Bray to City Centre Core Bus Corridor (Bus Connects) Scheme

Bord Pleanála Case reference: HA27.317742

Cora Plant & D O'Muirthile
25 Seaview Park Shankill Co. Dublin
14th July 2024

Image 3.13: Section 3 Route Options Remaining After Stage 1 Sifting (Bray to UCD CBC Feasibility and Options Report (NTA 2017))

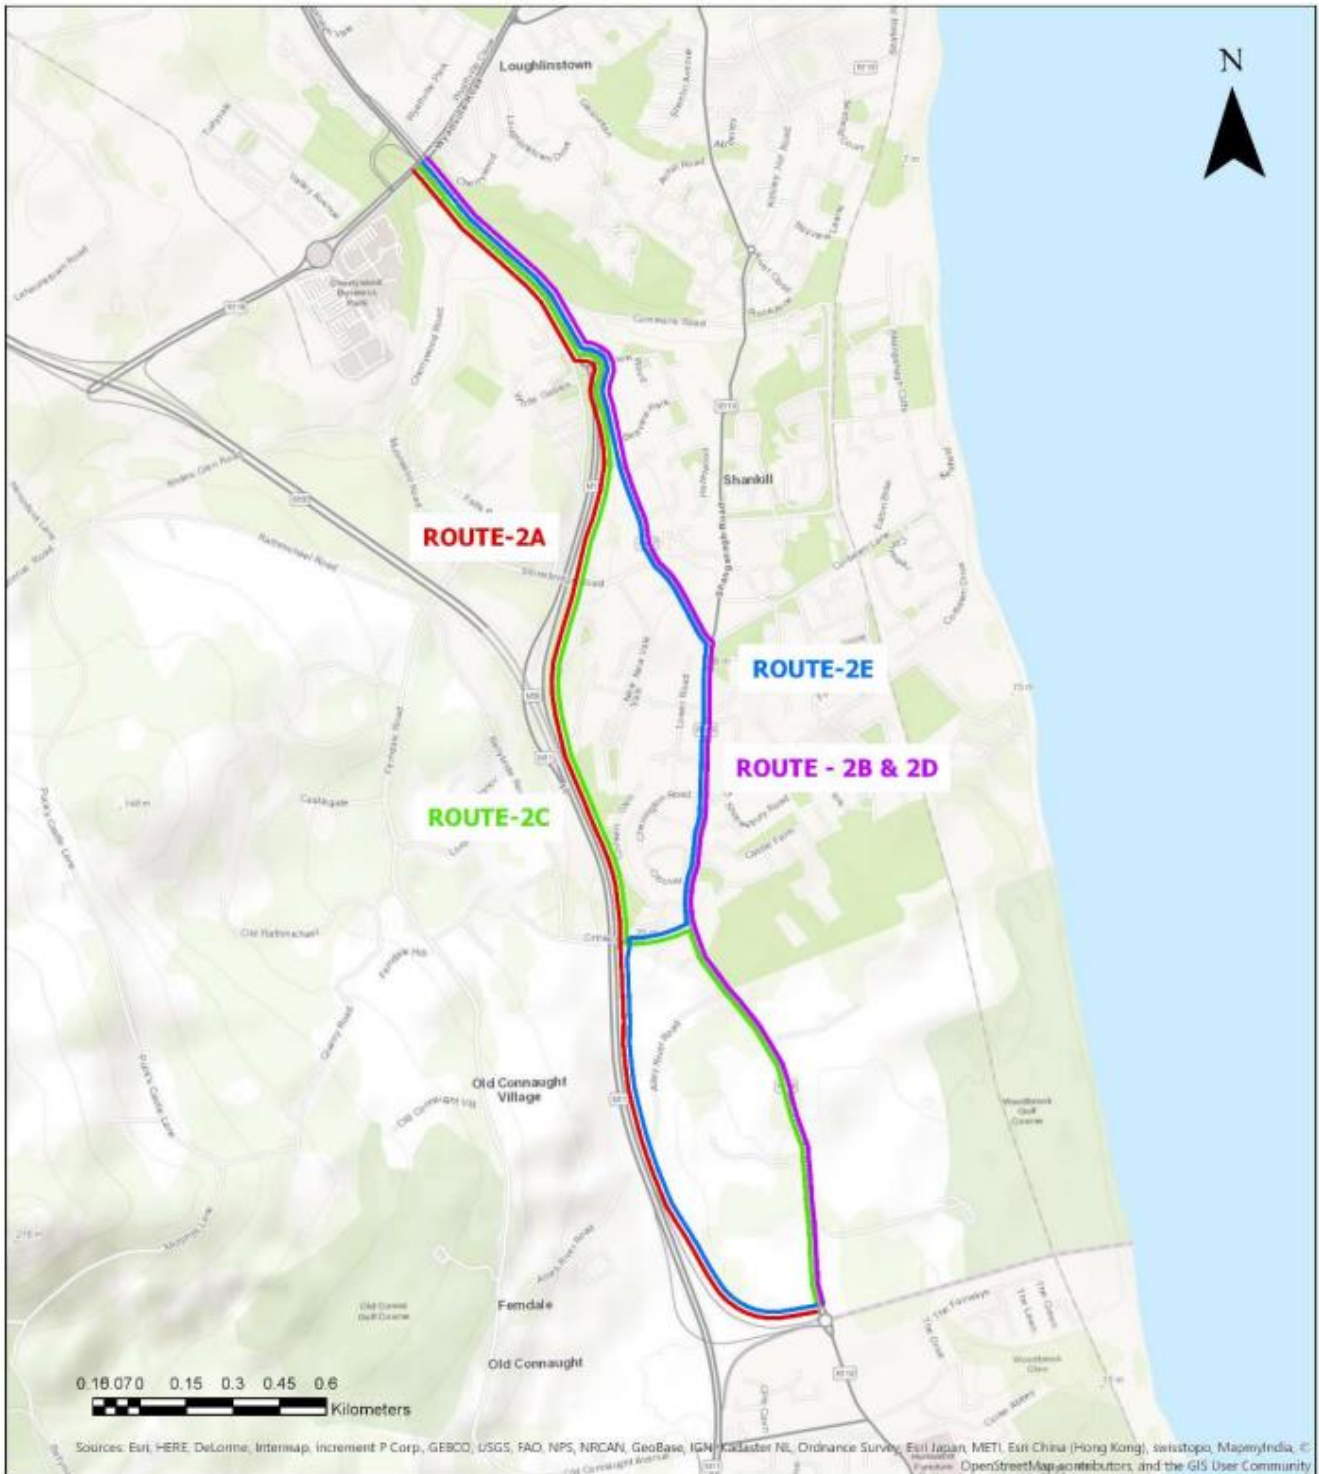
The applicant's response has failed to address the fact that Route Option 2B cannot possibly still be considered the preferred route (notwithstanding that it was always less preferable from an environmental perspective) on the basis that:

- It was originally considered to have the lowest capital cost, however this assessment failed to consider the potential cost benefits of combining (or partly combining) with the N11/M11 Bus Priority and proposed LUAS schemes as outlined previously, and also failed to consider the associated economic impacts during the construction phase in comparison to any less impactful offline routes.

- It was originally considered to provide a high-level of service for bus passengers, however this was on the basis of much more dedicated bus infrastructure, much of which has now either been removed or replaced with less dependable bus priority signals.
- It was originally considered to provide continuous dedicated cycle facilities, which quite clearly it no longer does, instead forces cyclists to share lanes with vehicles.
- It was originally considered equal with alternate routes from a safety perspective, whereas this can no longer be the case given the removal of cycle infrastructure (and notwithstanding the failure to undertake a proper Stage F safety audit at route selection stage).

It is clear that the original comparison are no longer valid, and given the acknowledged significant long term impacts, can no longer be justified without proper re-assessment.

Image 3.15: Alternative Cycle Route Options Through Shankill (Bray to UCD CBC Feasibility and Options Report (NTA 2017))

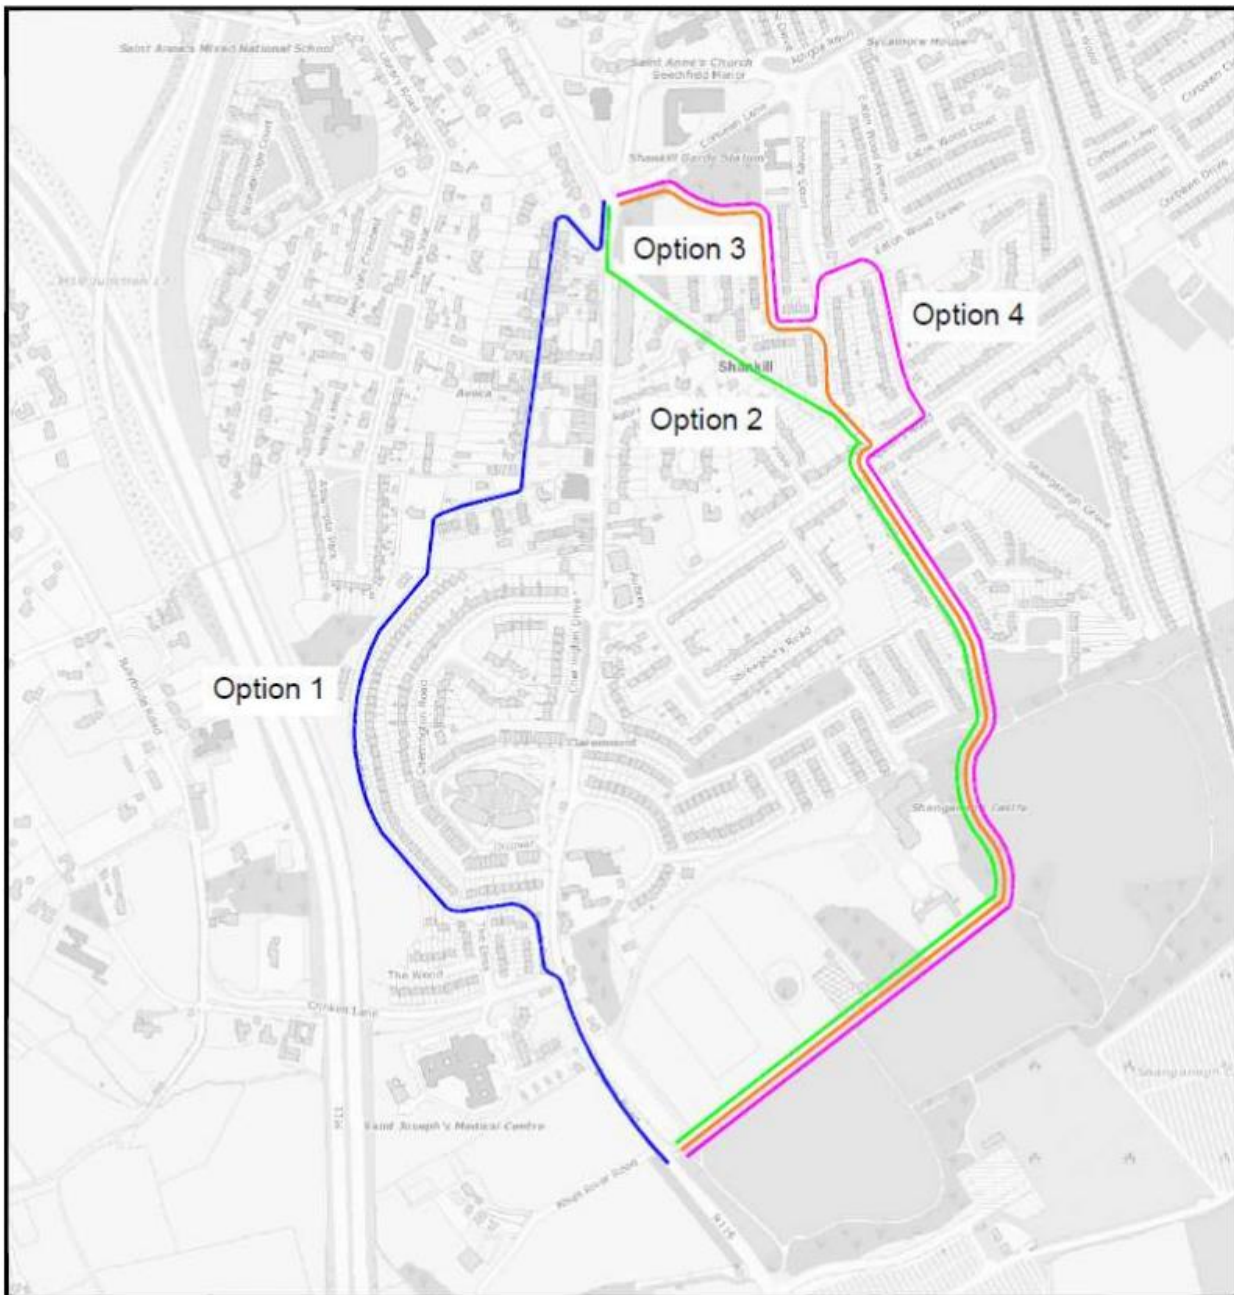
The justification for lack of provision of suitable and safe cycle infrastructure along the proposed route, particularly from Loughlinstown Roundabout through Shankill village, has not been satisfactorily addressed in the applicant’s submission. Indeed the applicant cites the lack of segregated cycle facilities as a justification for not selecting a particular route (pg 511, the application notes “sharing of bus lanes” by cyclists as a reason for not selecting a route as it “*would not meet the proposed scheme objectives and impact the safety of cyclists*”). Similarly, the applicant has proposed a reduced speed limit of 30km/h through Shankill village as a suitable mitigation for shared lanes, yet contradicts itself by contending that cyclists (presumably of all ages including young children) will be safe sharing a lane with buses and taxis at 50km/h on the Dublin Road.
